**From:** [Dan Grove](#)  
**To:** [Molly McGuire](#)  
**Subject:** Development Proposal Site for Permit 2207-019 is Illegally nonconforming  
**Date:** Friday, June 16, 2023 8:27:41 AM  
**Attachments:** [6950 Illegal Nonconforming Status \(1\).pdf](#)

Molly McGuire  
Mercer Island Community Planning and Development Department  
RE: Development Site for Permit 2207-019 is Illegally Nonconforming  
June 15, 2023

I'm writing to ensure that an important set of Site and Critical Area violations in SUB3 of Mercer Island Permit 2207-019 (address: 6950 SE Maker Street) are addressed. The problems I lay out about the site are in addition to the issues I've already identified around the elevation, grade, size, and setbacks for the proposed structure that I laid out in my June 9, 2023 email.

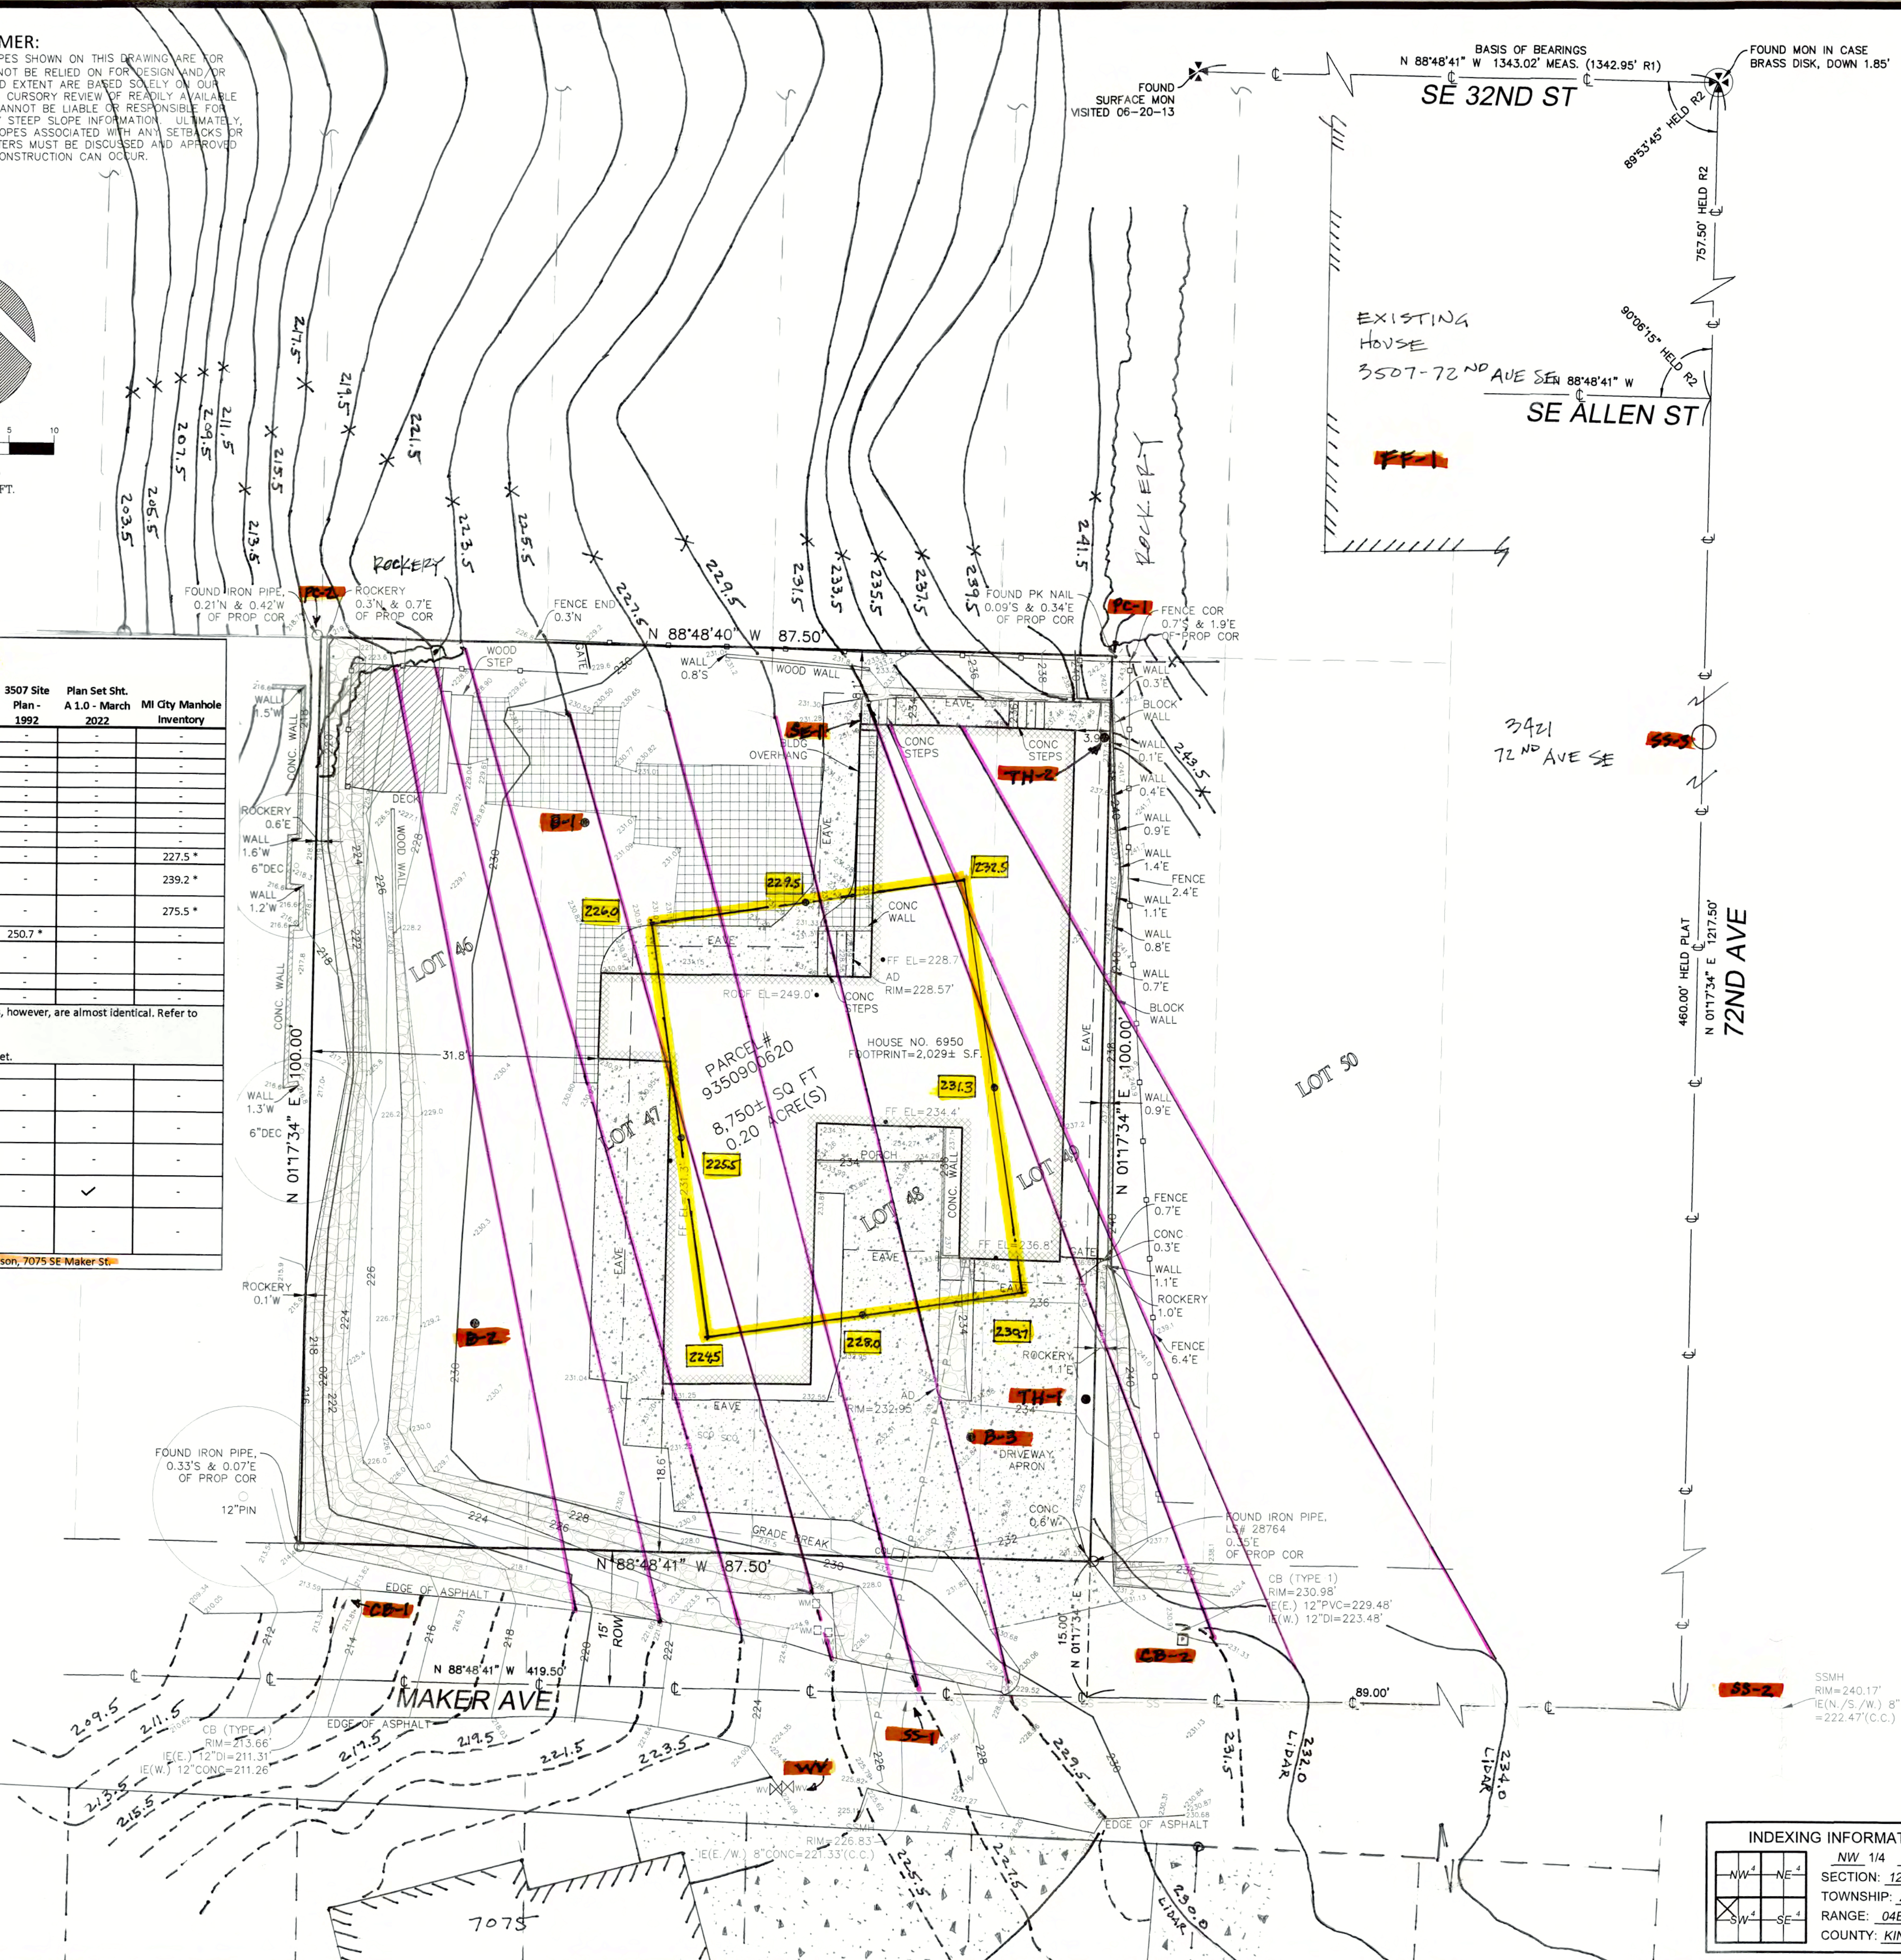
Another survey of SE Maker Street and 6950 SE Maker was done in 2021, as shown in Figure 3. The rockery installed after 1963 significantly altered the grade of the front and side yards of 6950 SE Maker (north and east of the rockery), as a second fill installation was done (to fill in the area behind the rockery, and to increase the grade of the front/side yards).

A comparison of cross sections (shown in Figure 4) of the 1963 Survey in figure with the 2021 Survey from 2207-019 clearly confirms that the rockery was installed between the dates of the two surveys. In these two surveys, 60 years apart:

- The elevation of the Maker Street midline (shown in Blue) is differs from 1963 to 2021 by only a few inches (despite the street being paved several times between the two surveys)
- At the south boundary of 6950 (in Green), the rockery that was added is clearly visible - as you can see, there are up to 4 feet of difference between 1963 and 2021.
- The cross section 10' north of the boundary (in Red) shows that the rockery increased the elevation of the yard by 7.5 feet when comparing 2021 and 1963 elevations.

- 19.02.050(D)(5) - The proposed rockery + retaining wall in the western Required Side Yard exceeds its maximum height of 72 inches. The proposed rockery + retaining wall in the western Side Yard is between 96 and 144 inches above the existing grade. As should be obvious, the Existing Grade at the bottom of the wall is the Existing Grade from which the height of the proposed rockery + retaining wall must be measured.

- 19.02.050(E)(1) - the proposed rockery/retaining wall in the Required Front Yard exceeds the maximum height of 42 inches. The proposed rockery + retaining wall in the Required Front Yard is up to 156 inches (13 feet) high. As I have demonstrated in other filings, the current grade of SE Maker Street is the correct Existing Grade for the southern border of the Lot, and is the height from which the height of the proposed rockery + retaining wall must be measured.
